ADDRESS : 655 FLINTLOCK LN  
CONTRACTOR : J & W CUSTOM BUILDERS INC  
OWNER : NC CORRAL LLC  
PARCEL : 05-0624- - -0040- -03-  
APPL NUMBER: 16-50039383 CP NEW RESIDENTIAL (SFD)  
DIRECTIONS : US401NW/ L@ CHRISTIAN LIGHT/ L@ RIVER/  
L@ FLINTLOCK LN/ LOT IS ACROSS STREET  
FROM 634

STRUCTURE: 000 000 2800 SQFT 2BDR W/REC ROOM W/DECK CRAWL

## FIELD REPORT

Date : 12/7/16  
Project: 655 Flintlock  
Location: Fuquay-Varina, NC  
Company: \_\_\_\_\_  
Contact: Jason Miller  
Job Type: \_\_\_\_\_  
Job No.: \_\_\_\_\_

1 12" CMU GARAGE FOUNDATION WALL

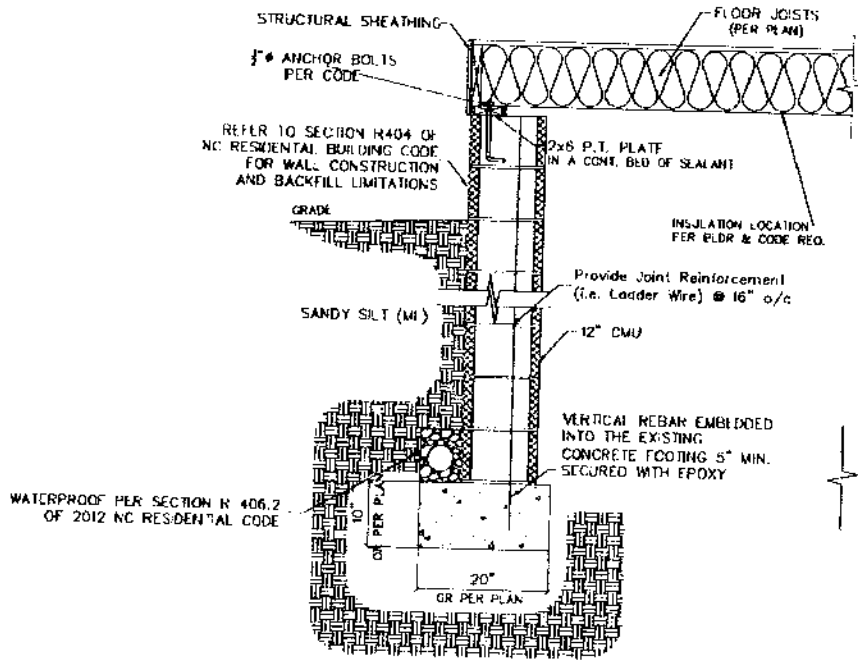
TYP/SQ	REQUESTED COMPLETED	INSP RESULT	DESCRIPTION RESULTS/COMMENTS
B101 01	9/19/16 9/19/16	BS DA	R*BLDG FOOTING / TEMP SVC POLE TIME: 17:00 VRU #: 002872752 T/S: 09/16/2016 09:13 AM JFORBES T/S: September 19, 2016 10:02 AM BSUTTON Engineered plan calls for #4 vertical rebar in all walls above 4 feet high, and all piers in each cell. This must b in place at time of footing inspection. Call to reschedule.
B101 02	9/23/16 9/23/16	BS AP	R*BLDG FOOTING / TEMP SVC POLE TIME: 17:00 VRU #: 002875524 T/S: 09/22/2016 12:13 PM LBENNETT T/S: 11/15/2016 09:33 AM DJOHNSON
A814 01	12/01/16 12/01/16	SB AP	ADDRESS CONFIRMATION TIME: 17:00 VRU #: 002904878 655 FLINTLOCK LN FUQUAY VARINA 27526 POST ADDRESS AT LONG DRIVE WAY T/S: 12/01/2016 09:31 AM SBENNETT
B103 01	12/02/16 12/02/16	BS AP	R*BLDG FOUND & TEMP SVC POLE TIME: 17:00 VRU #: 002905784 T/S: 12/01/2016 01:40 PM JFORBES T/S: December 02, 2016 09:17 AM BSUTTON Engineering attached

Roof Framing

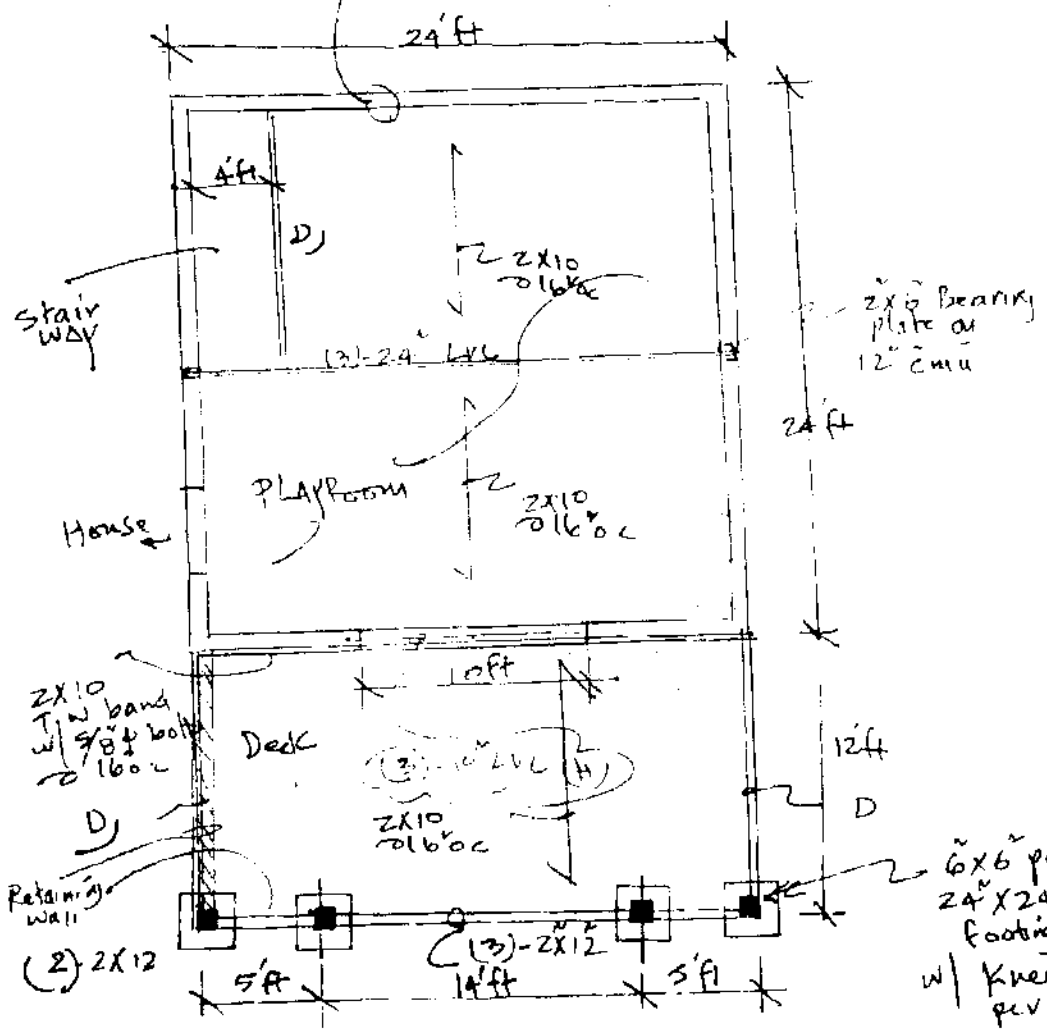
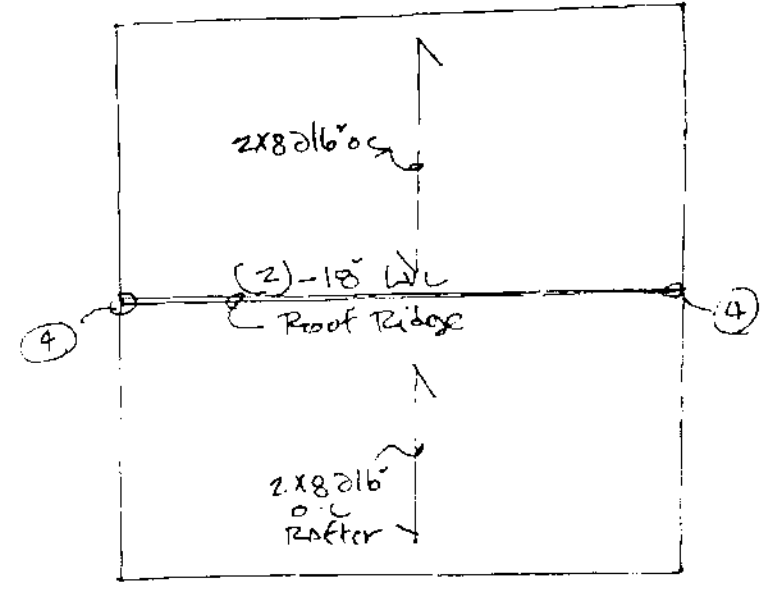
TYP/SQ	REQUESTED COMPLETED	INSP RESULT	DESCRIPTION RESULTS/COMMENTS
			Need attic access over main portions of house. Small garage does not require attic access (less than 400 Sqft)2. Need engineering on master roof redesign. 3. Strap washing machine vent. 4. INstall fireplace for inspection. Do not cover chimney before inspection (factory built wood burner) Ok to insulate
E207 02	2/16/17 2/16/17	BS AP	R*ELEC TEMP SERVICE POLE TIME: 17:00 VRU #: 002934149 T/S: 02/15/2017 03:21 PM LBENNETT ----- T/S: February 16, 2017 07:56 AM BSUTTON -----
I129 01	2/20/17	TI	R*INSULATION INSPECTION TIME: 17:00 VRU #: 002934883 T/S: 02/17/2017 10:41 AM DJOHNSON -----
R425 02	2/20/17	TI	FOUR TRADE ROUGH IN TIME: 17:00 VRU #: 002934875 T/S: 02/17/2017 10:41 AM DJOHNSON -----

(A) Roof Ridge (32ft long) at master bedroom  
(3) - 2x12 LVL w/ (6) - 2x6 studs  
each end will be sufficient.

NOTE - AT CRAWL SPACE FRAMING, BLOCK DOWN  
at each end of new Ridge, and  
Install 6x6 posts on 20x20x10" footings.
